**WELWYN HATFIELD BOROUGH COUNCIL  
EXECUTIVE DIRECTOR - PLANNING, PUBLIC PROTECTION AND GOVERNANCE**

**DELEGATED APPLICATION**

**Application No:** 6/2017/0491/HOUSE  
**Location:** 97 Bramble Road, Hatfield, AL10 9SB  
**Proposal:** Erection of a single storey front extension, two storey side extension and part single, part two storey rear extension.  
**Officer:** Mr D Elmore

**Recommendation:** Granted

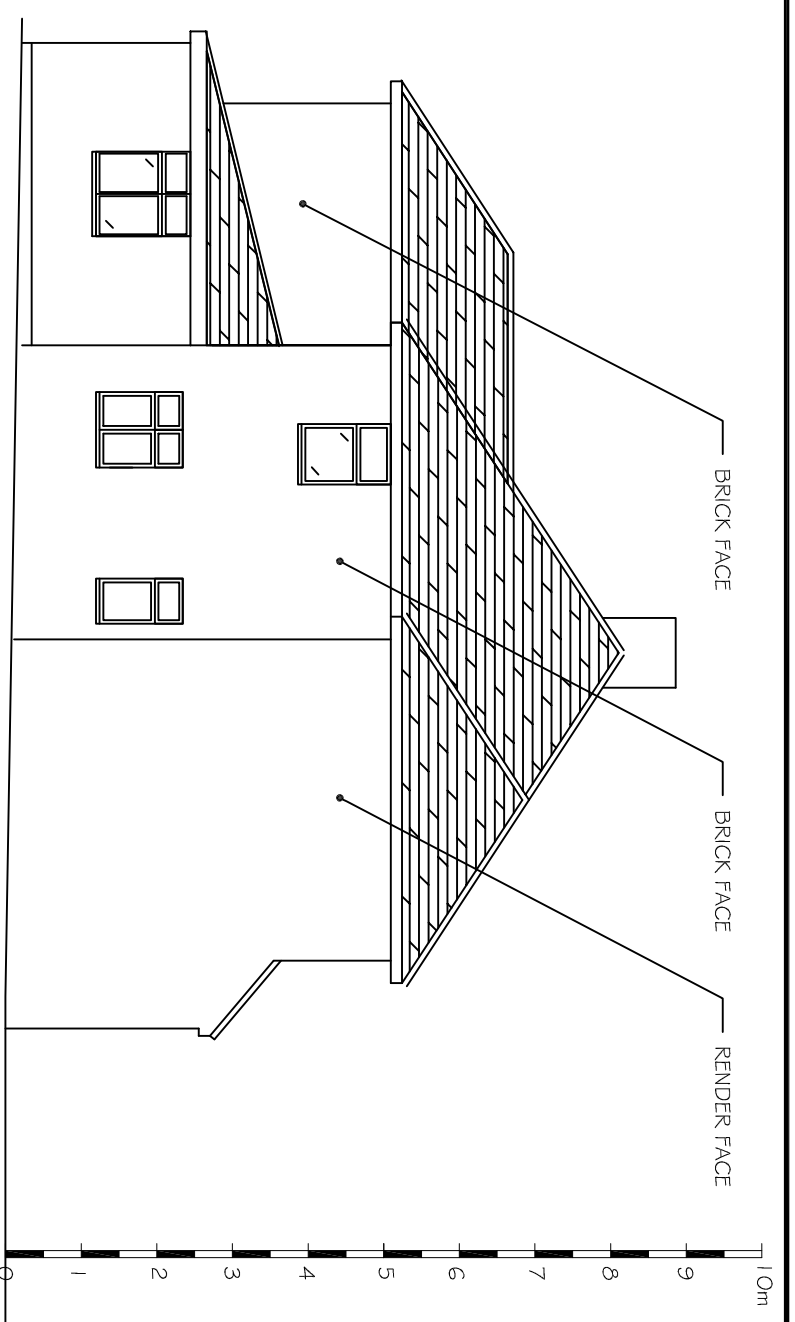
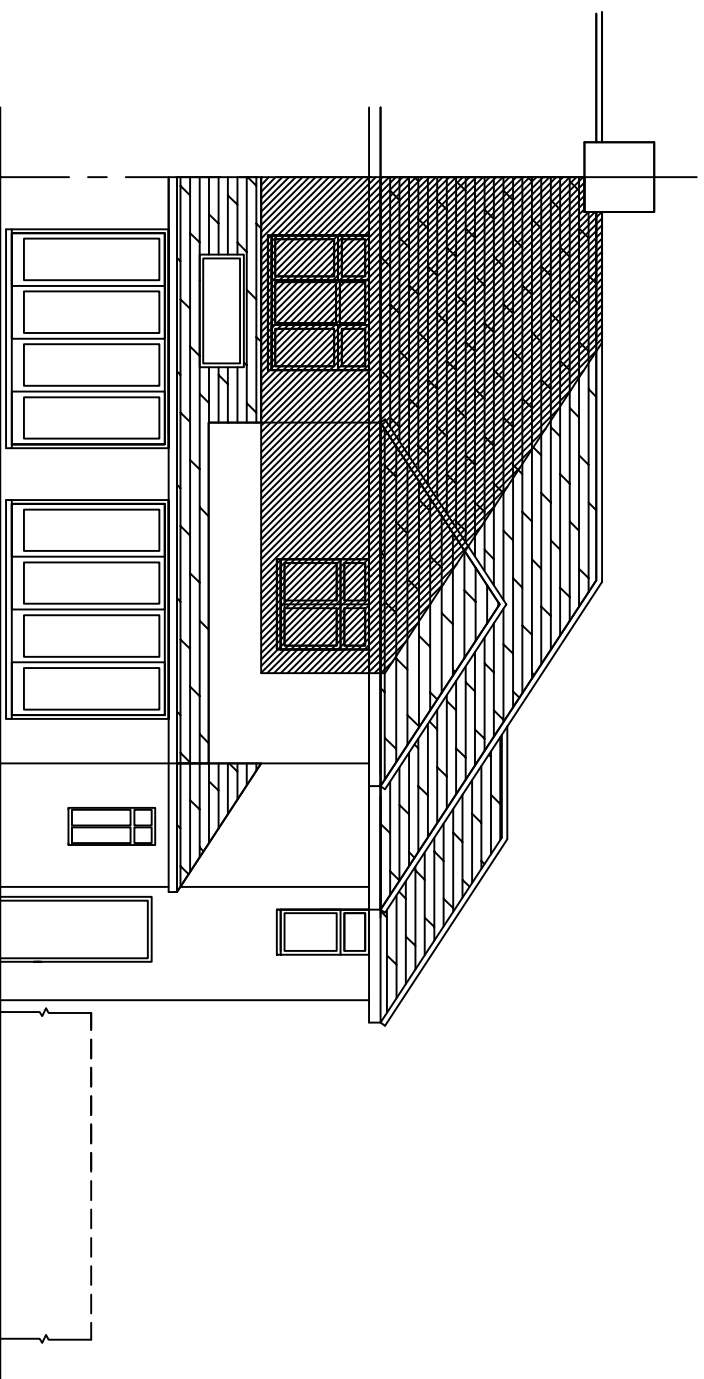
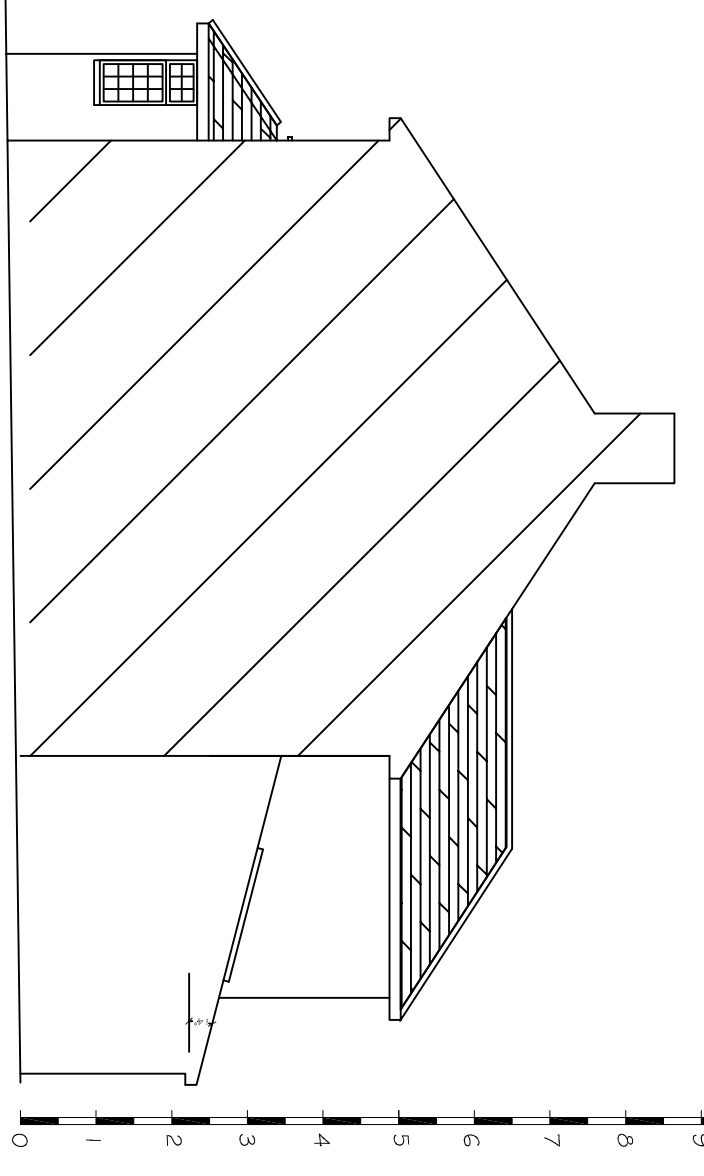
External materials used in the extensions should match that of the host dwelling. This can be secured through planning condition.			
<b>Would the development maintain the amenity of adjoining occupiers? (e.g. privacy, outlook, light etc.)</b>			
<input checked="" type="checkbox"/> Yes <input type="checkbox"/> No			
<b>Comment:</b> The proposed development would be overly dominant or result in loss of light, as a result of length of projection, height or proximity the adjoining/adjacent properties.

Subject to the first floor window facing No. 95 Bramble Road being glazed in obscure glass and with restricted opening, in order to protect the levels of privacy currently enjoyed by the occupiers of this adjacent property. This can be secured through planning condition.

2. The first floor side window of the proposed development facing No. 95 Bramble Road shall be glazed with obscured glass and shall be fixed so as to be incapable of being opened below a height of 1.7 metres above floor level, and shall be retained in that form thereafter.
